FALCON RESERVE FILING NO. 1

STORM & PCM CONSTRUCTION PLANS

OCTOBER 2025

FALCON RESERVE FILING NO. 1
COUNTY OF EL PASO, STATE OF COLORADO
STORM & PCM CONSTRUCTION PLANS
OCTOBER 2025

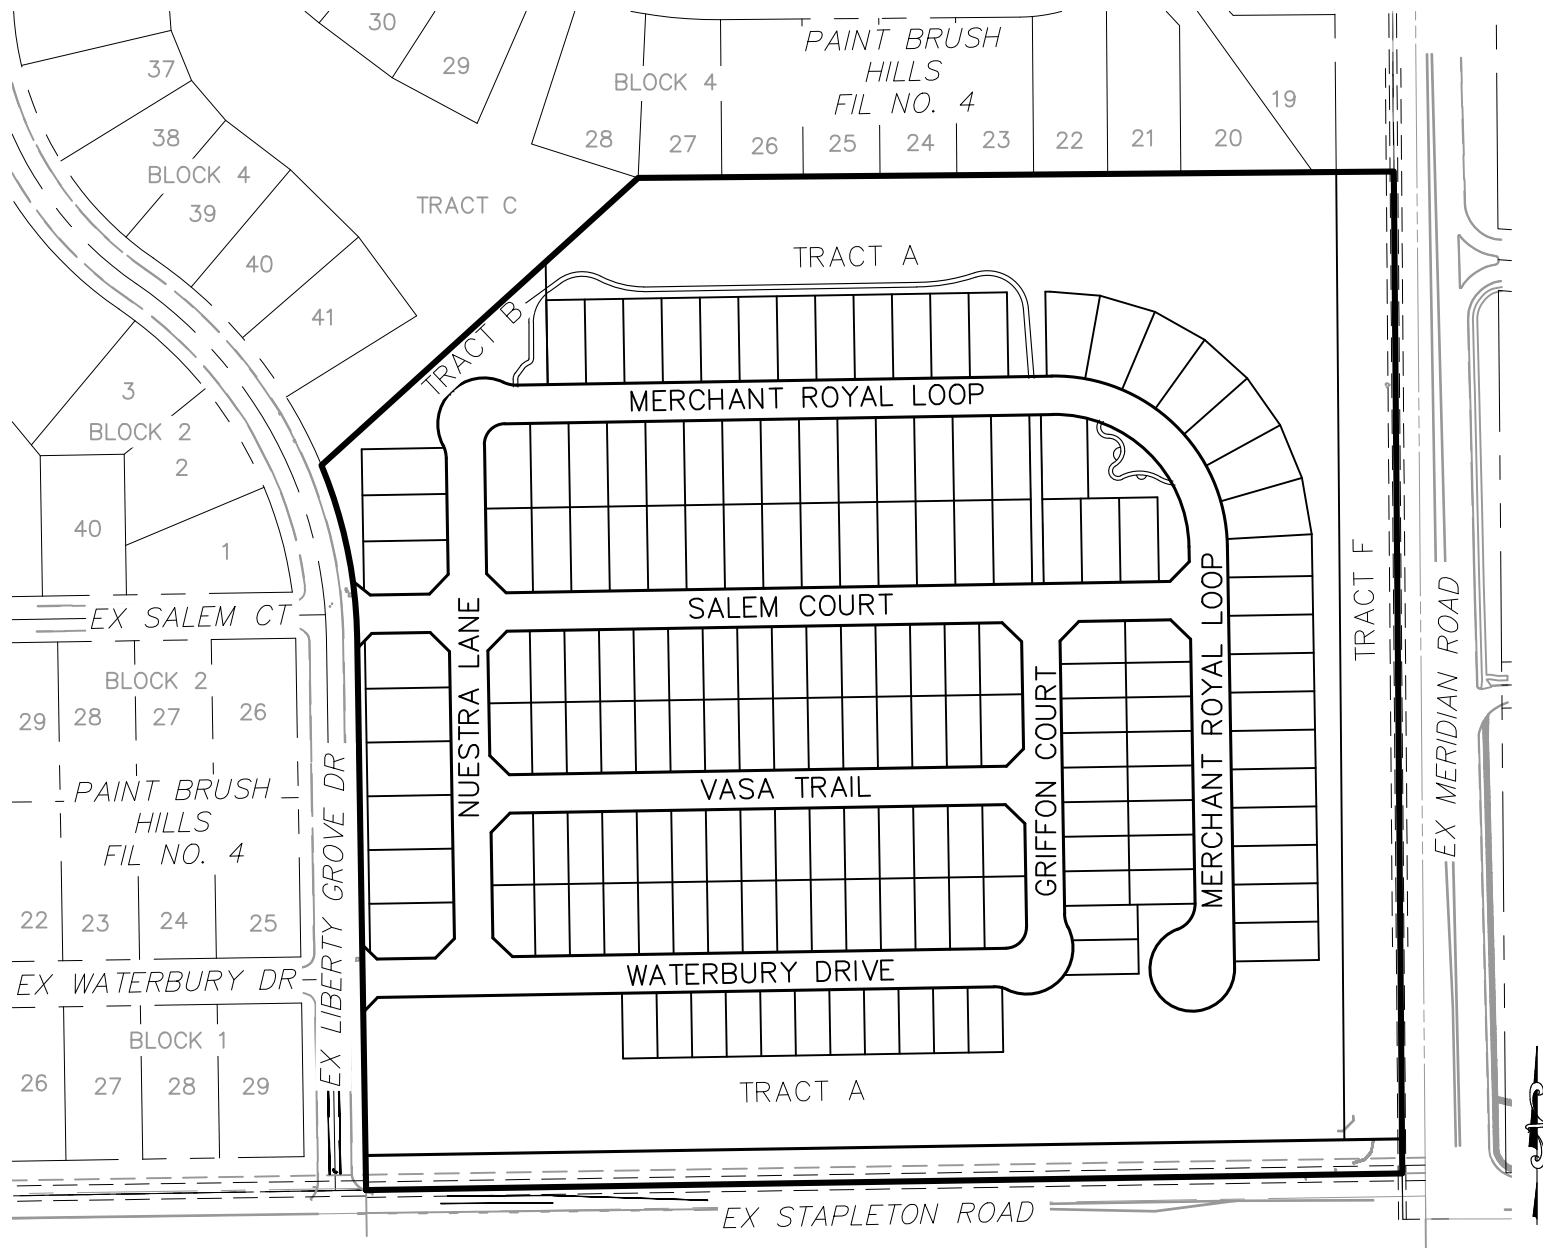
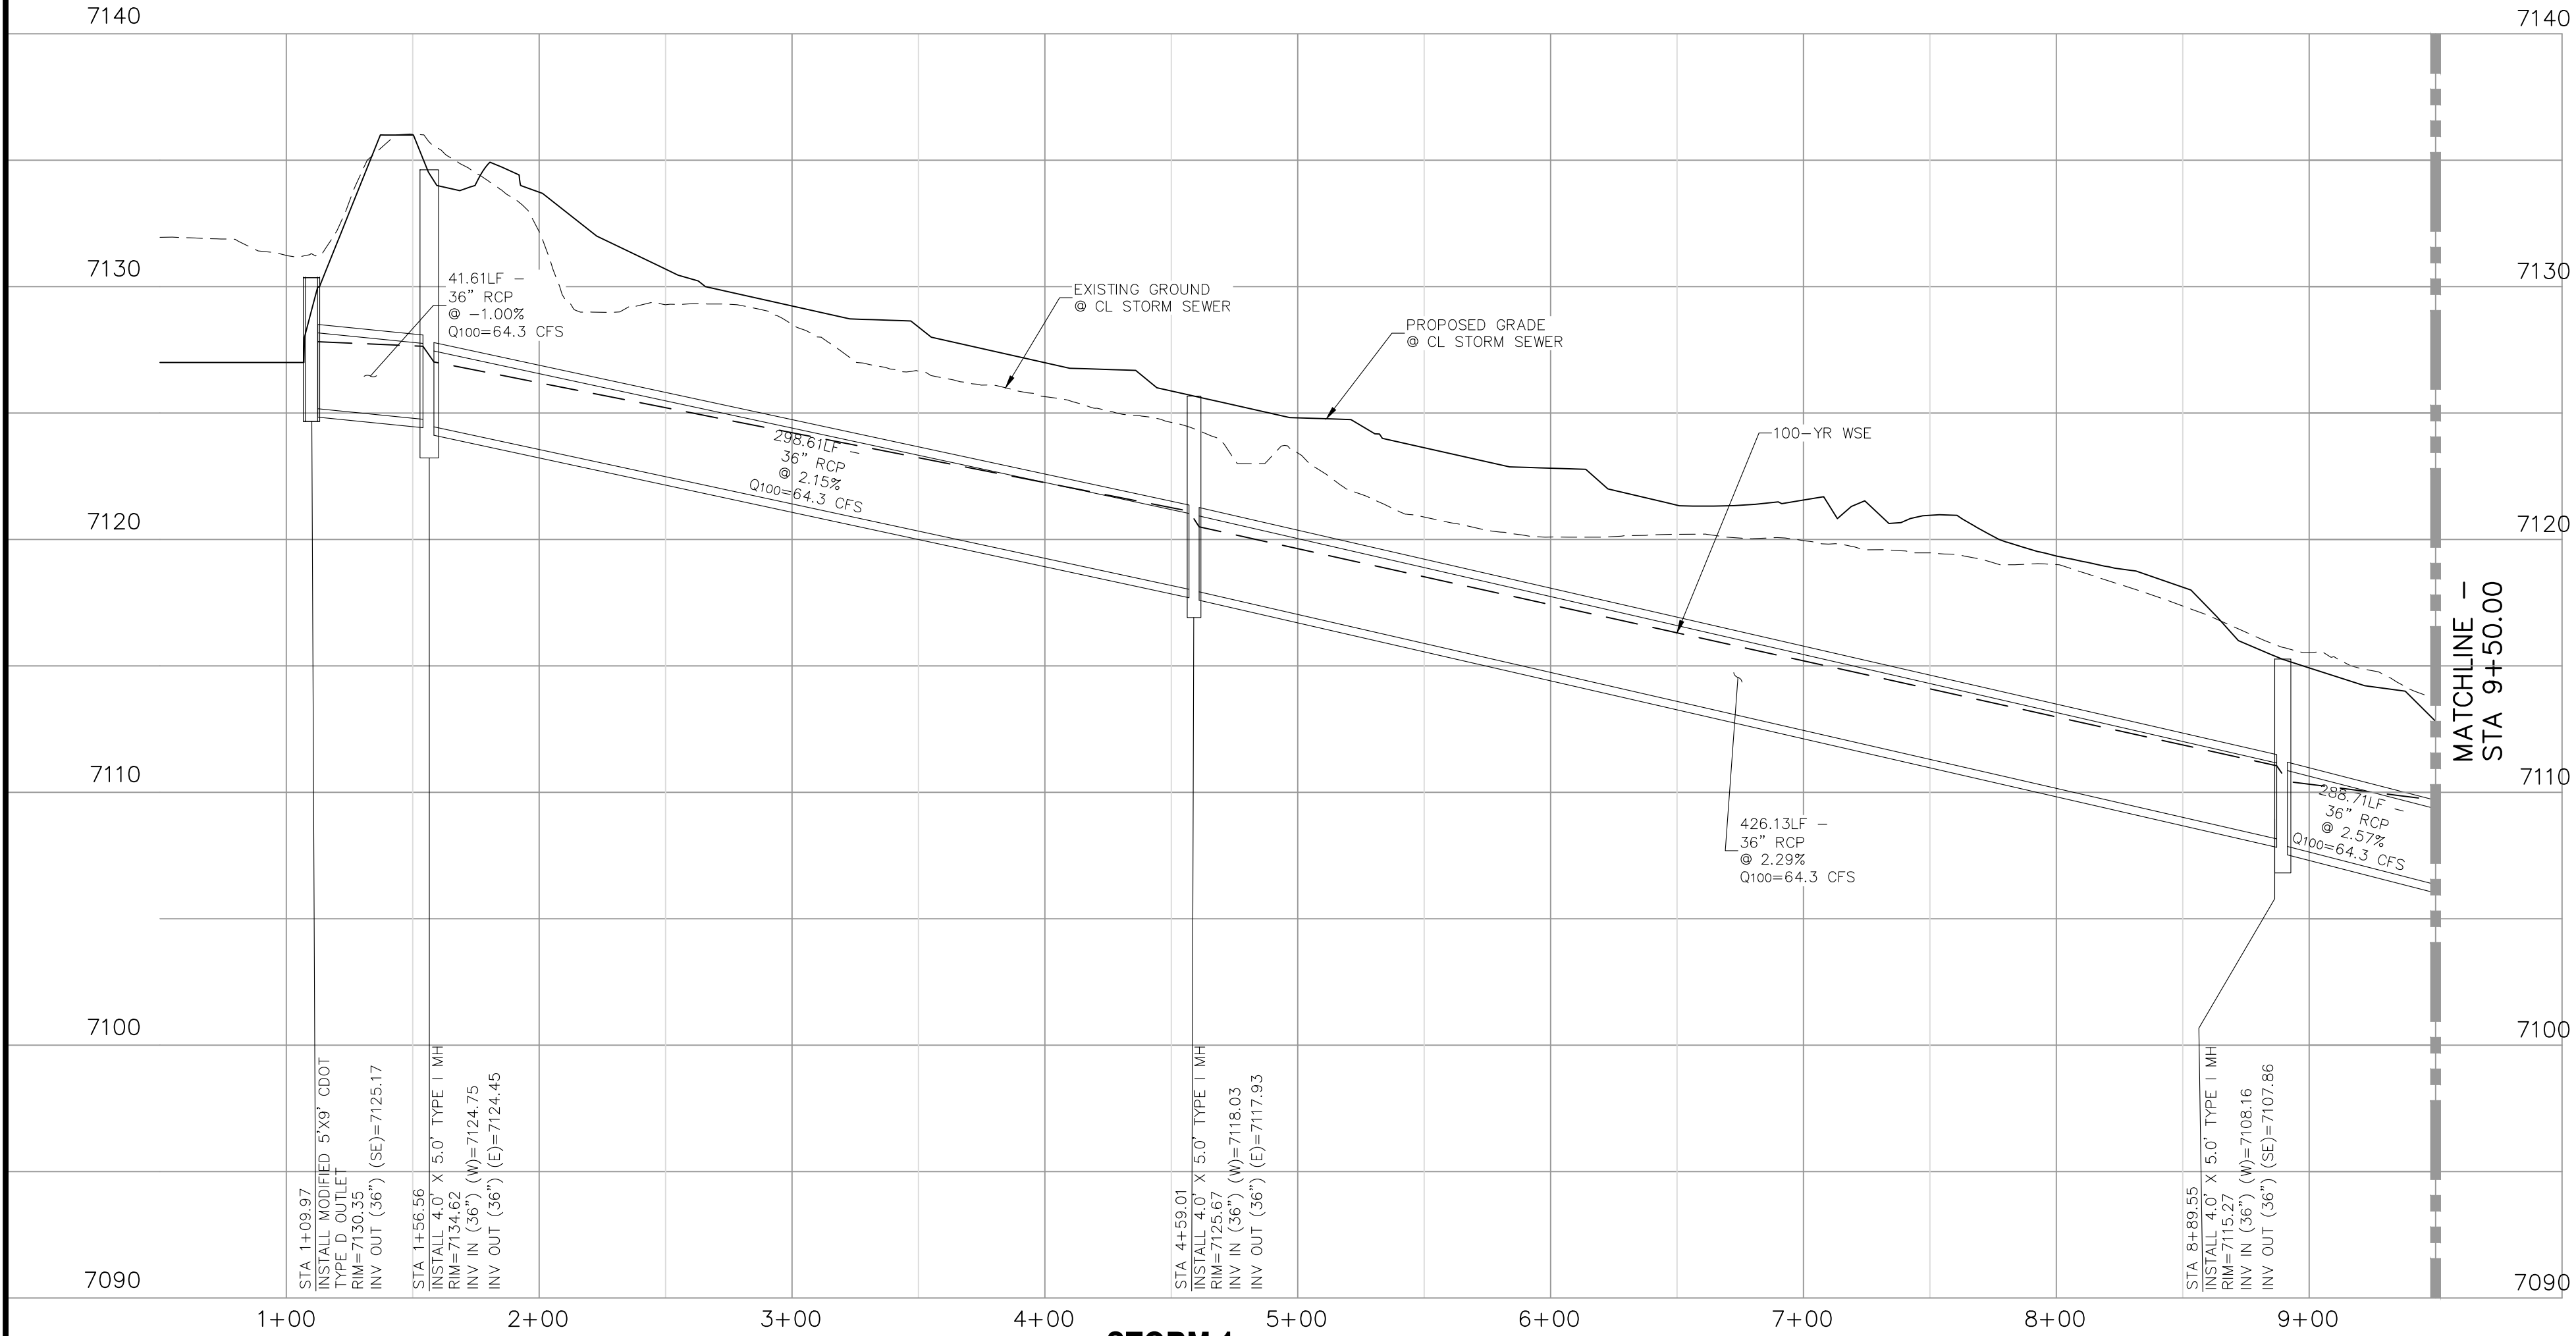
Can just combine one set for all CDs and GEC
as they are the same sheets
See Comments on CD set

All plans Storm,
PCM and GEC are
all combined as
requested.
